March 2010
Prepared by: Brian Maguire
100023

Preliminary BCA Assessment Report

Ingham Health Research Institute

IHRI Liverpool

A-1005

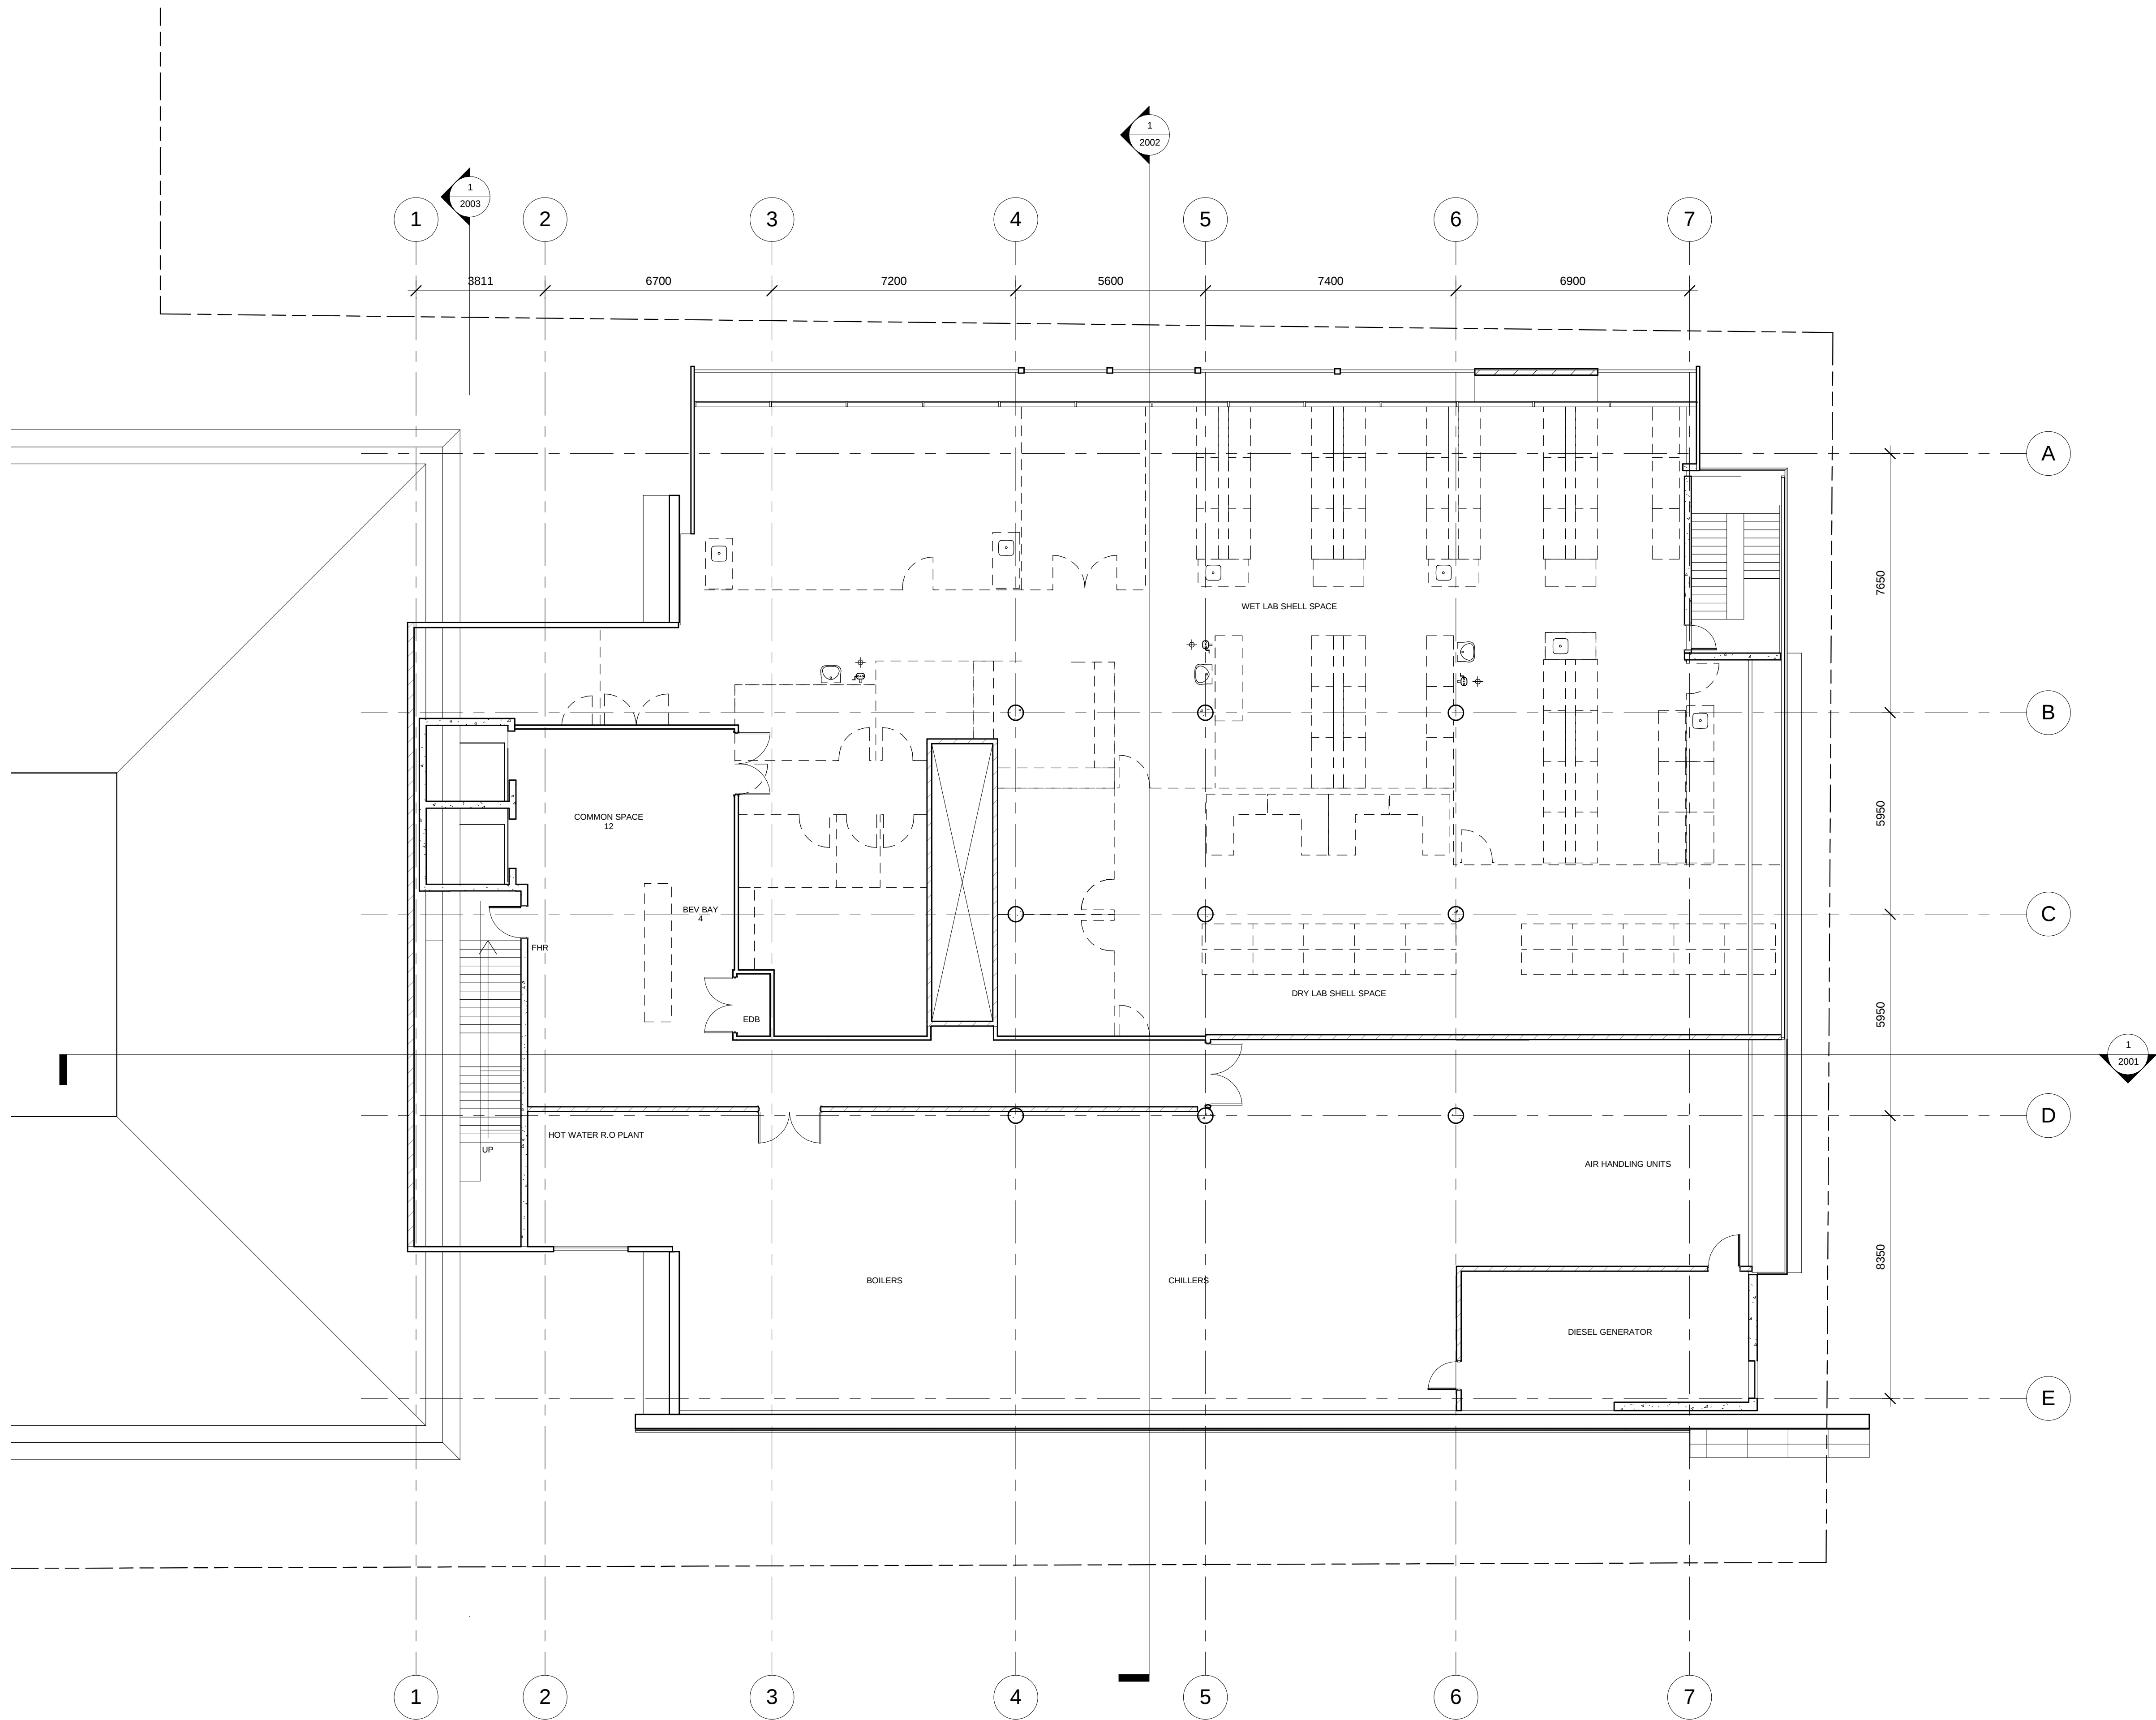
- d. Reduce the level of construction of the atrium in the building less than what is required under BCA Part G3.
 - e. Egress from Level 5, i.e. the fire rated alternative exit from the floor discharges into level 4.

- Excessive distance to a point of choice between alternative exits is to be addressed within the Level 5 plant room (i.e. maximum 20m).
- AS1428.1 compliance is required for circulation throughout the floors.

- Level 5 –
 - Fire isolated exit at the north eastern corner.
 - Fire rated/enclosed stair that connects to level 4 only and discharges adjacent to the horizontal exit below.

10. The distance to a point of choice between alternative exits within the Level 5 plant room will need to be addressed (i.e. maximum 20m).
11. Aggregate exit widths have been assessed and results in a maximum occupant number of 200 persons per floor.

A-1001

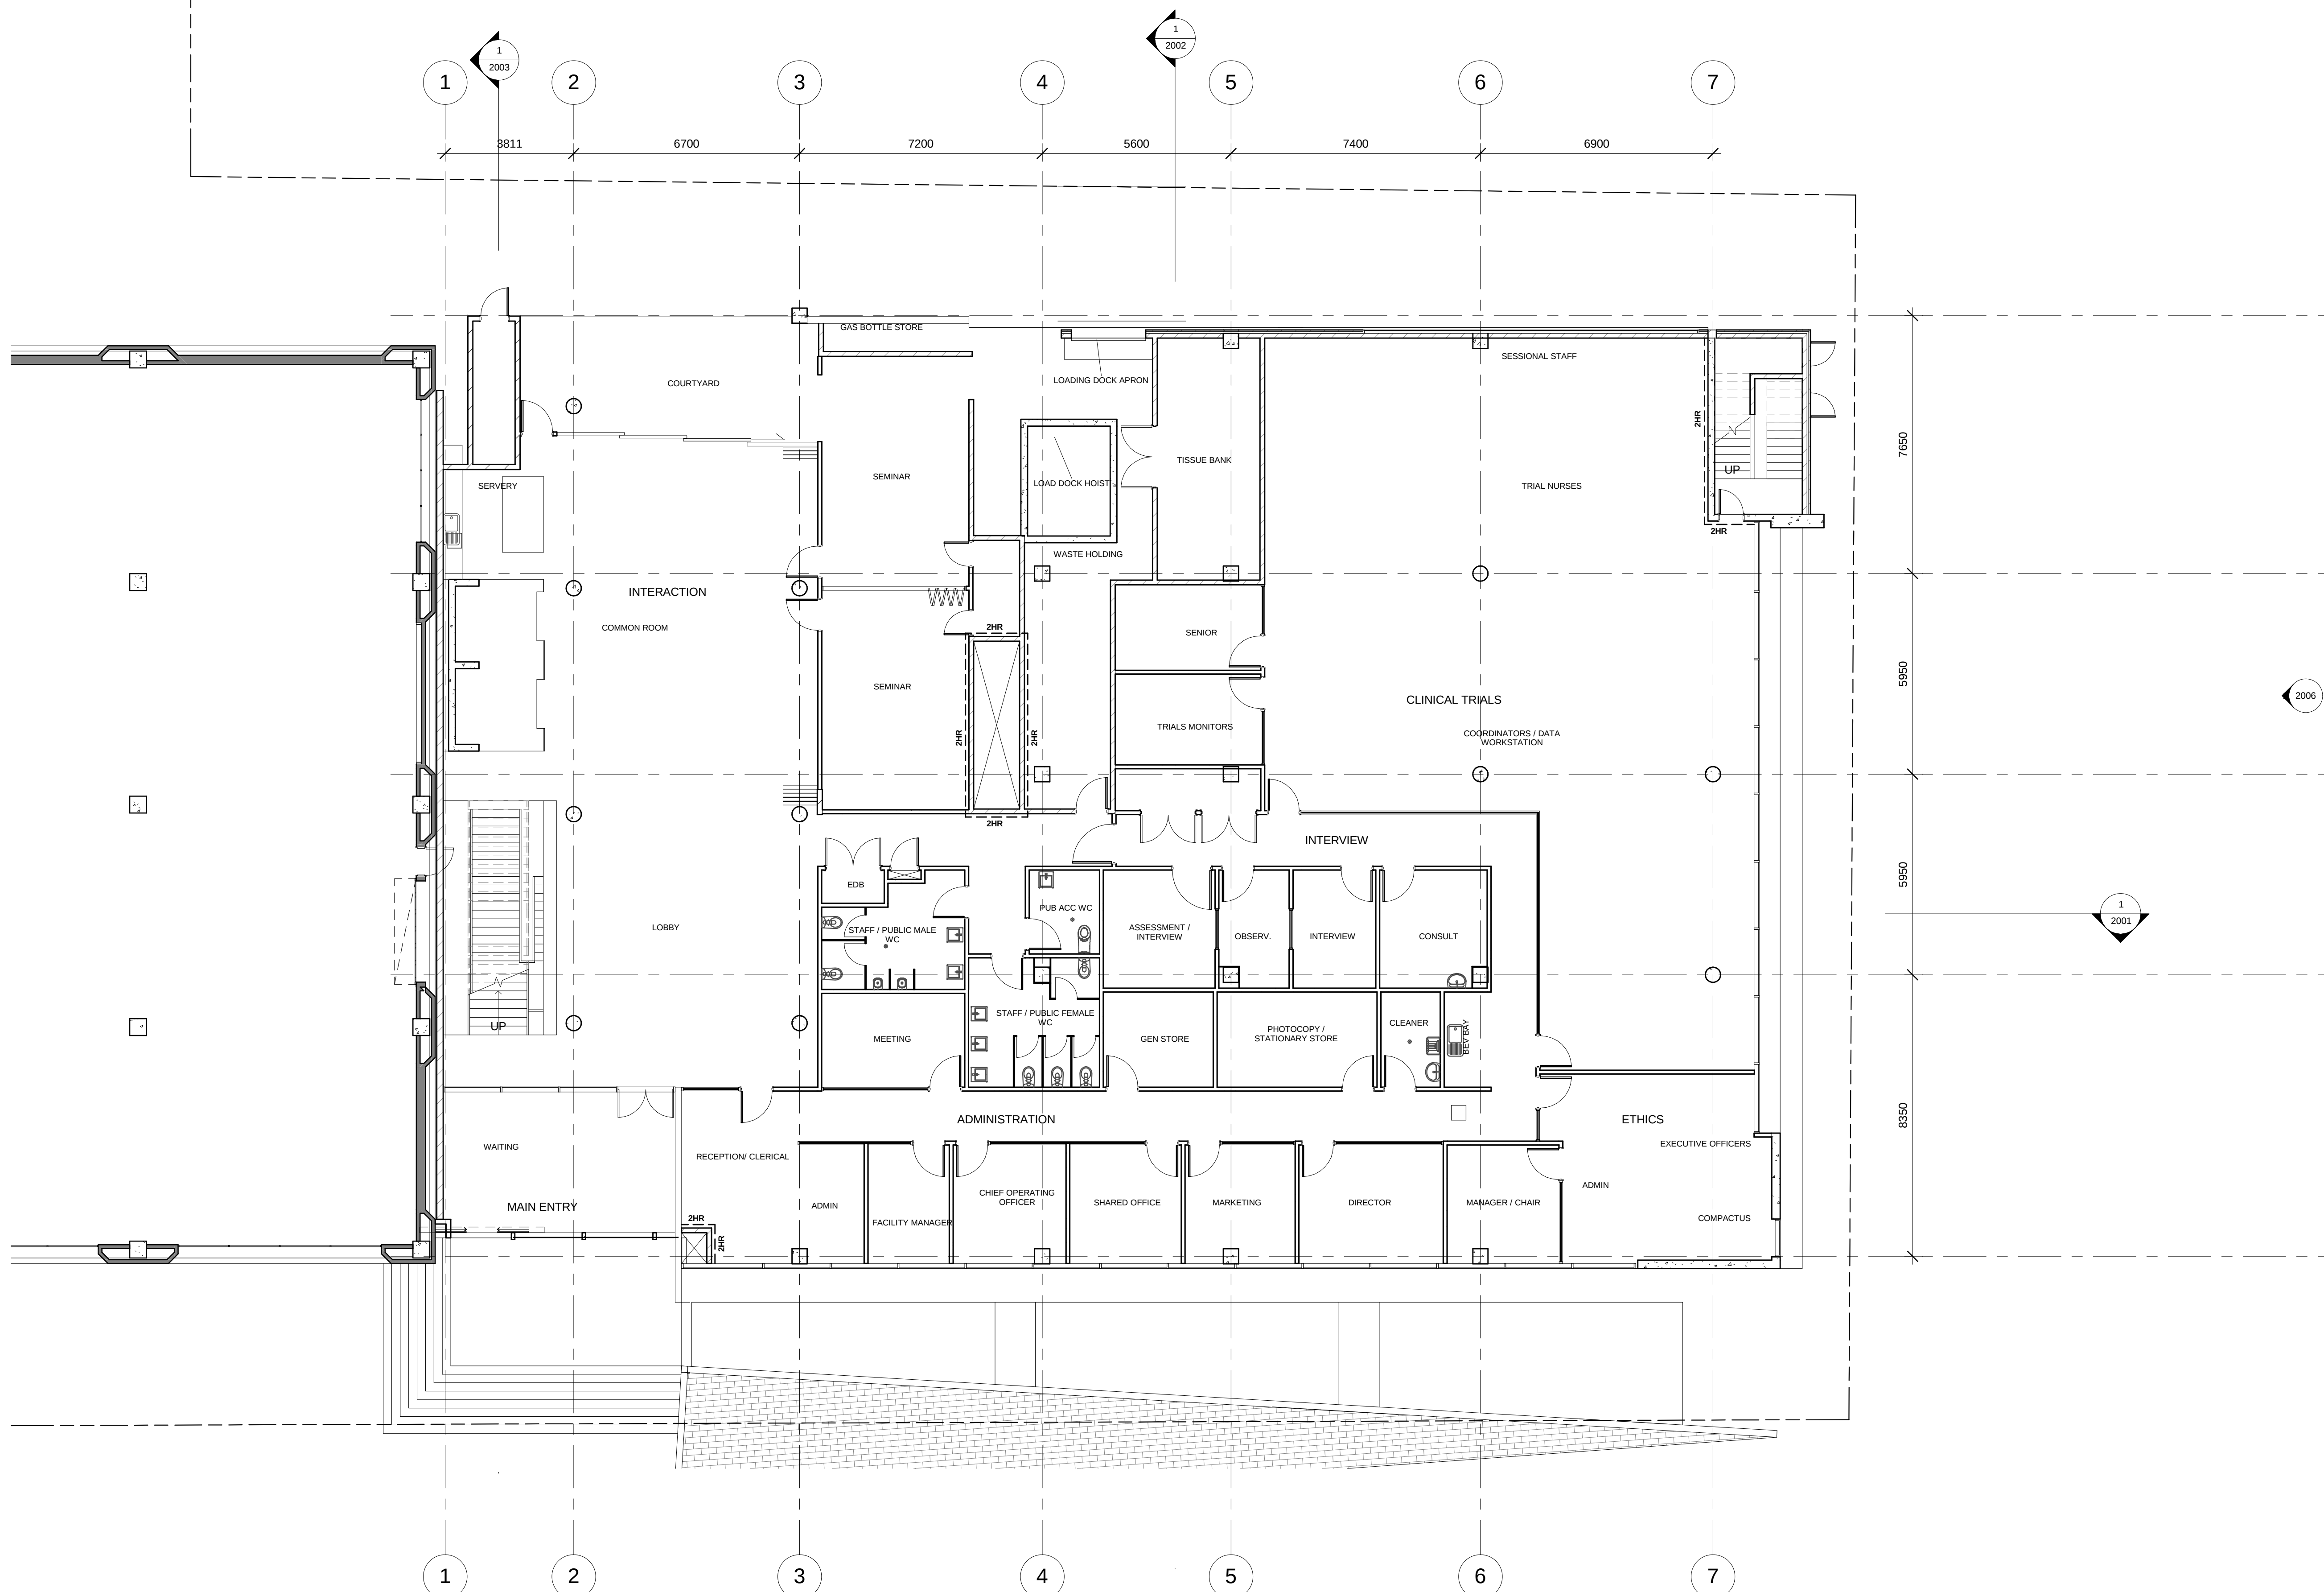
- Basement level –
 - Dedicated exit stair to the northern road;
 - Fire isolated exit stair at the north west corner of the building
 - Level 1 –
 - Inward swinging double door discharging southwards at the main entry;

13. Separation of rising and descending stairs in the northern fire isolated exit is to be addressed in accordance with BCA Clause D2.4. In this regard we assume that the stair discharges at Level 1 in an easterly direction, and therefore there needs to be non-combustible construction and smoke separation to result in no direct connection between the flights.

15. Main entry door to be rectified to swing in the direction of egress.
16. Access is required to be provided for persons with a disability to and within the building in accordance with BCA Table D3.2, i.e.
